Rezoning Transportation Analysis

Petition Number: 2020-134

Date	Description
10-20-2020	First Review (KP)
11-30-2020	Second Review (KP)
12-28-2020	Third Review (KP)

RZ-1.0

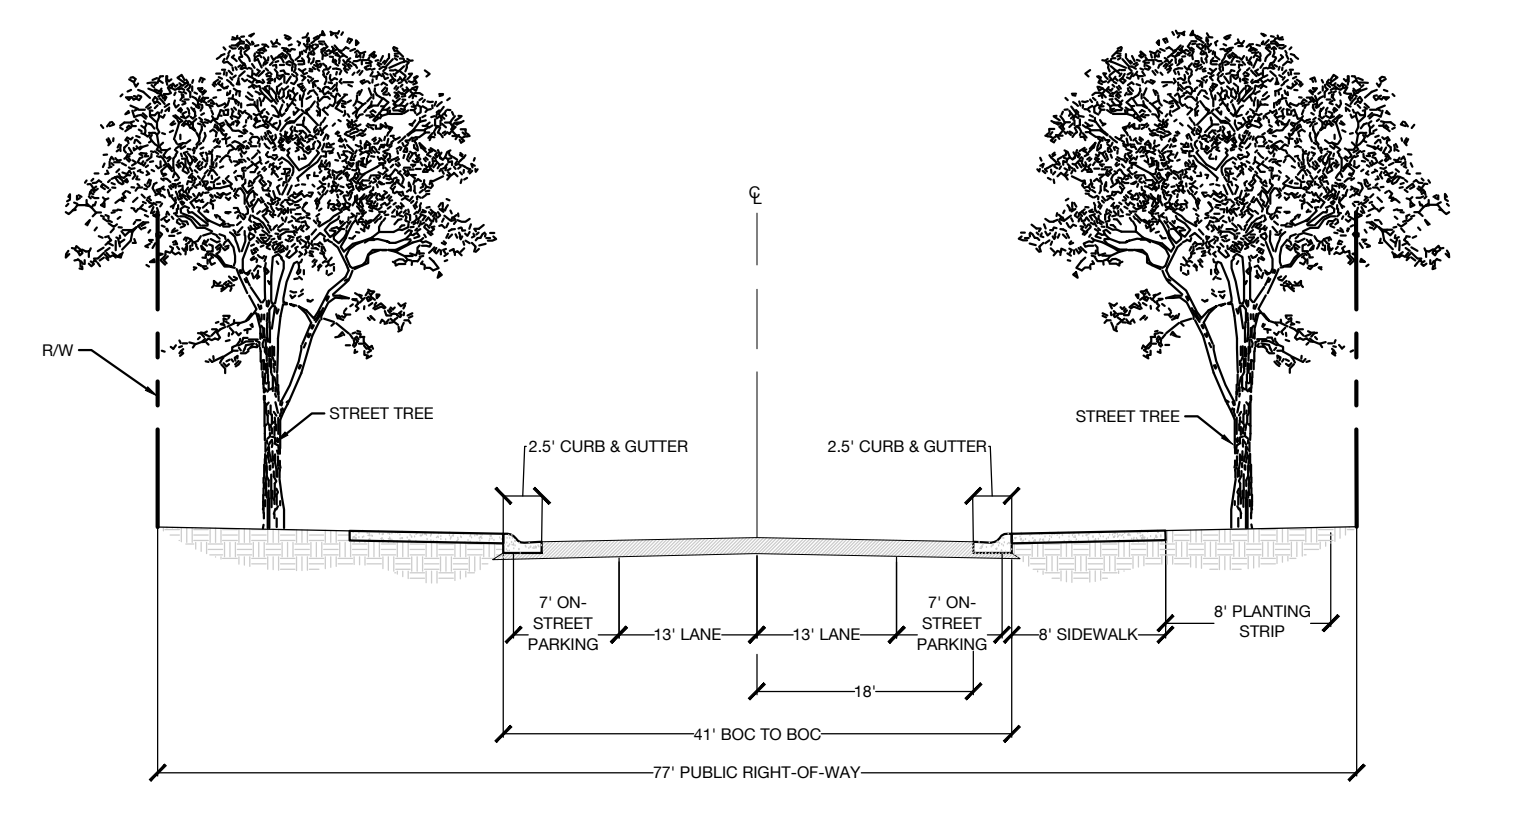
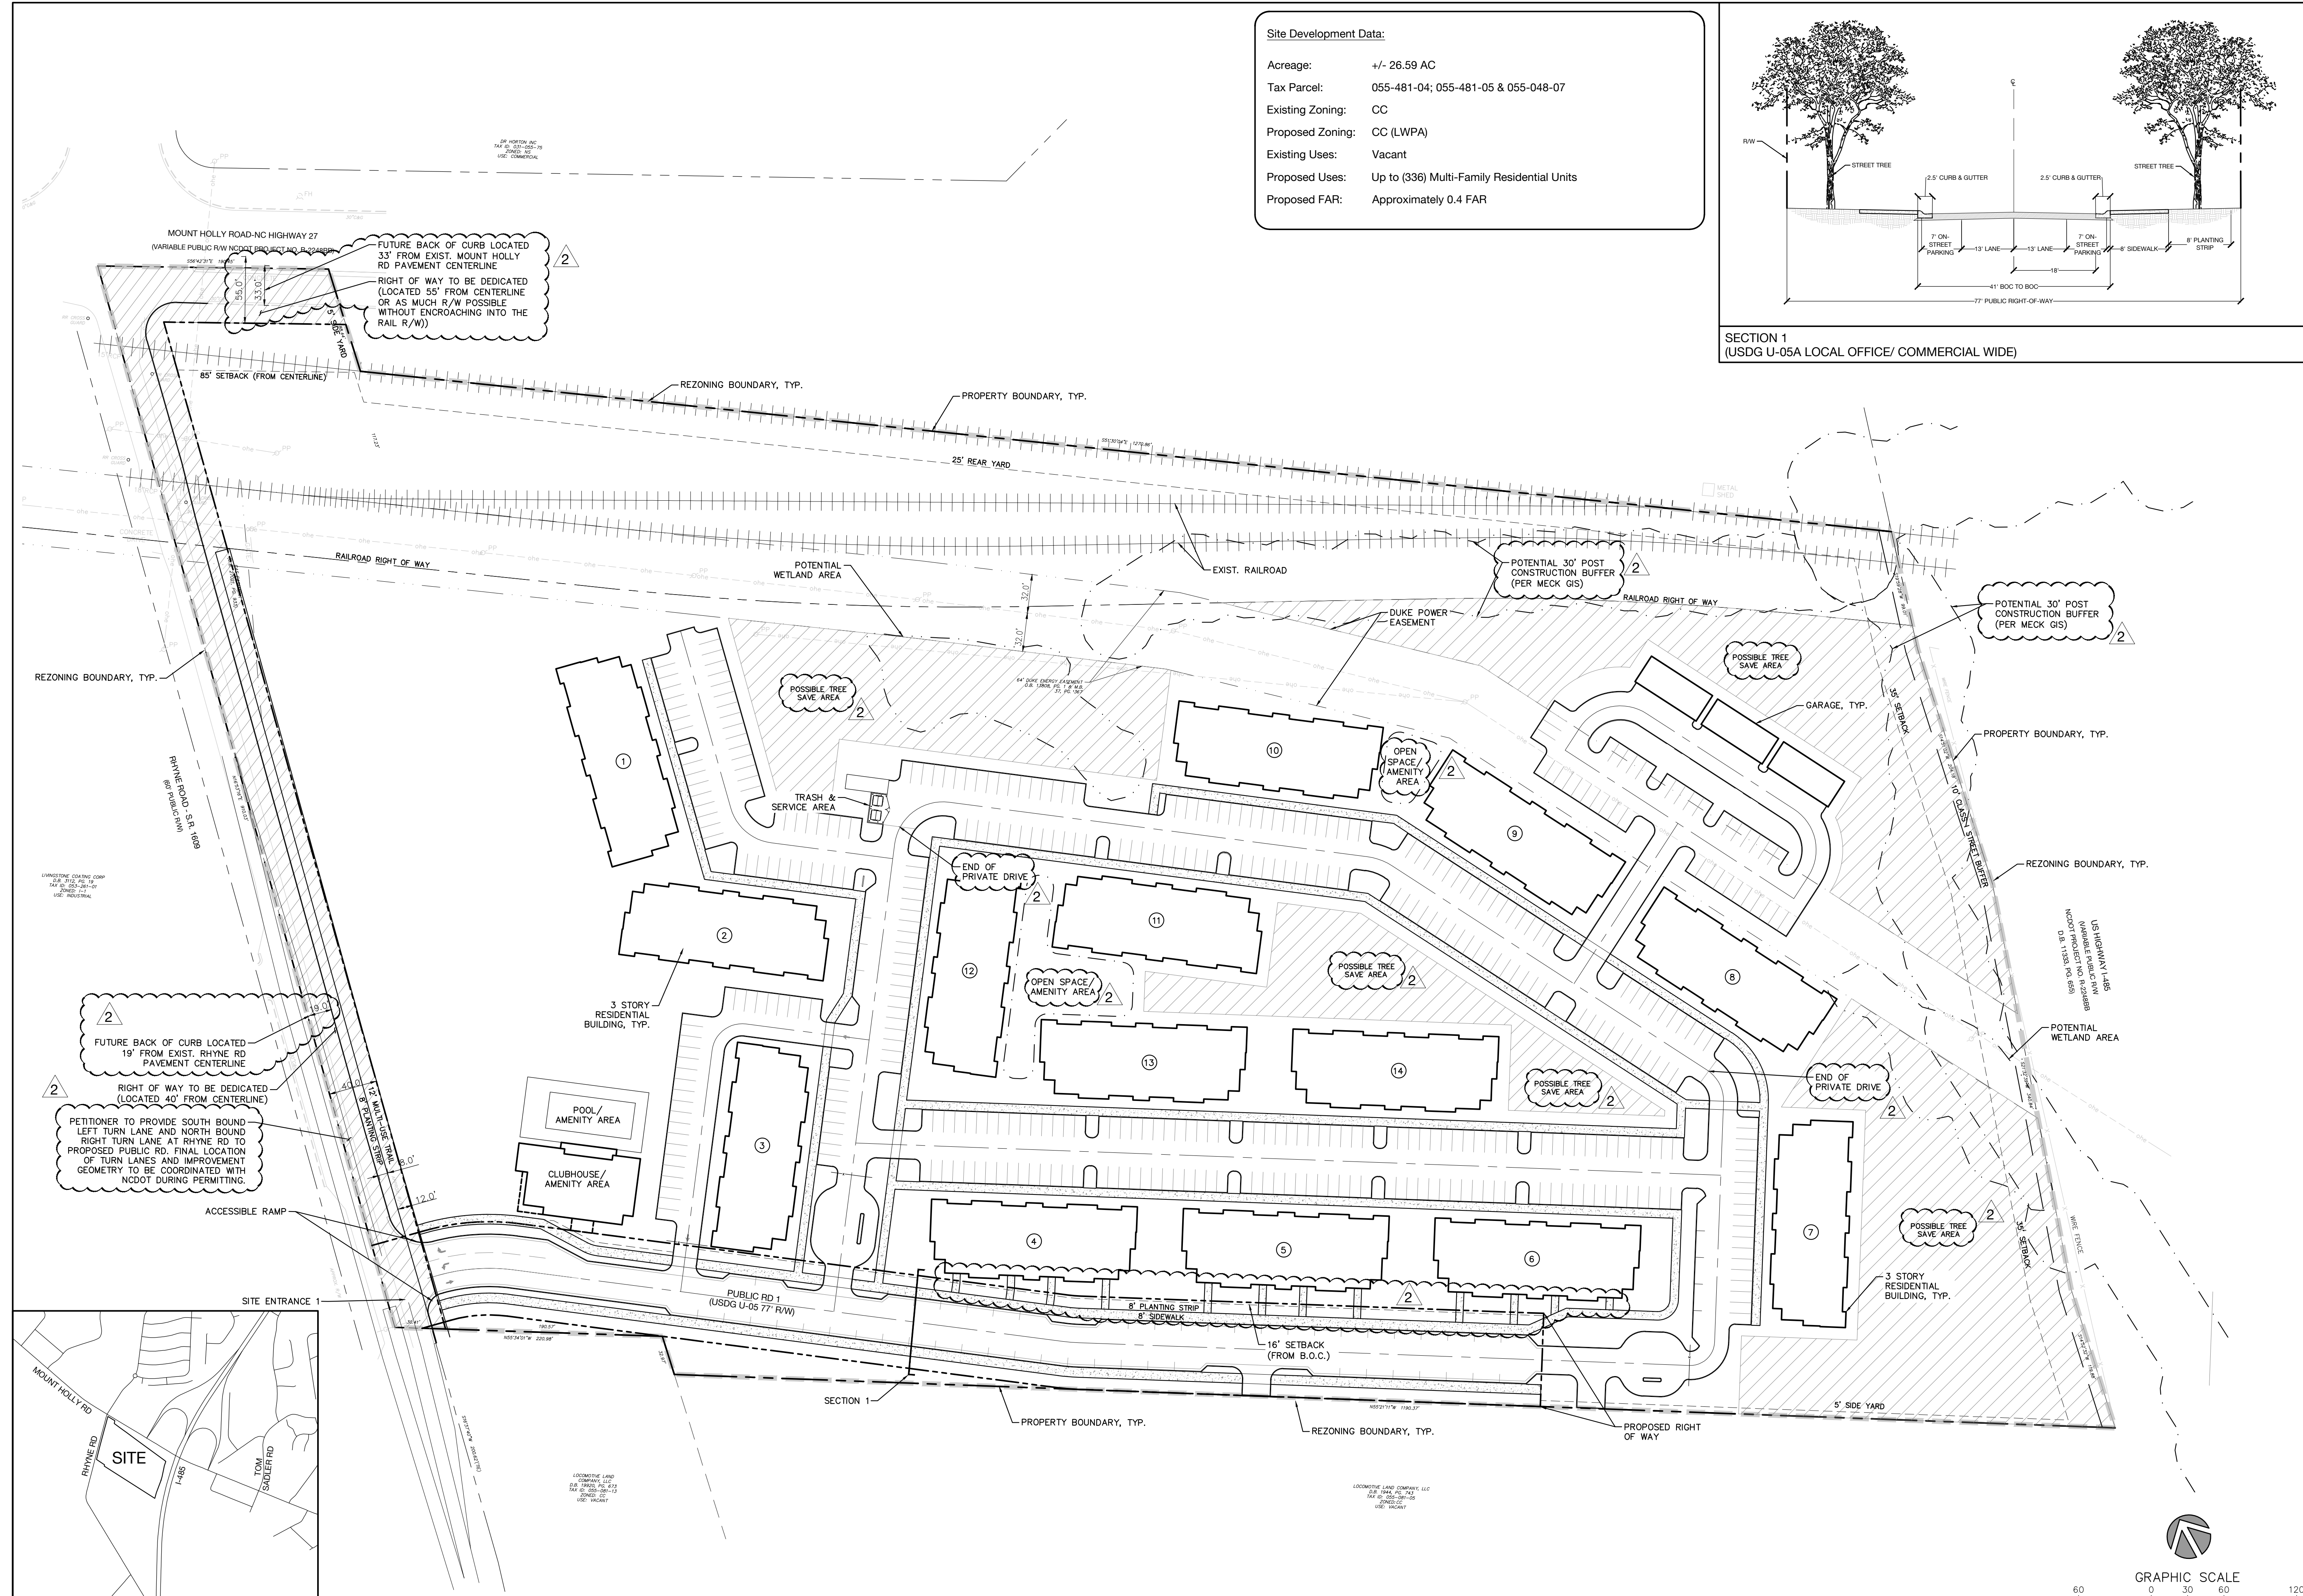
3. Right-of-Way Dedication:

- a. ~~Mt. Holly Road:~~ Revise the site plan and conditional note(s) to commit to dedicate 55-feet of right-of-way from the road centerline. ~~Update as a result from 11-16-2020 Site Plan:~~ Dedicate as much ROW as possible without encroaching into the Railroad ROW.
- b. ~~Rhyne Road:~~ Revise the site plan and conditional note(s) to commit to dedicate 41-feet of right-of-way from the road centerline. ~~Update as a result from 11-16-2020 Site Plan:~~ 40-feet of ROW dedication is acceptable.

The site plan should label and dimension the right-of-way from the road centerline.

5. ~~Rescinded.~~ Revise the site plan to show, label, and dimension the center lane median, on Rhyne Road, in front of Site Entrance 2, that will direct the right in right out movement(s). Also, include the commitment to construct this center lane median in the conditional notes.

6. Revise the site plan and conditional notes to commit to the construction of a three-lane cross section, as shown below, along the site's Rhyne Road frontage. Add to the conditional notes that center turn-lane storage and tapers will be coordinated with NCDOT during plan permitting.
 - a. ***Advisory Comment*:** In accordance with the construction of the 12-foot multi-use path as noted in item 4 of this CDOT memo, the 5-foot bike lane, as depicted in the cross section below, may be excluded.
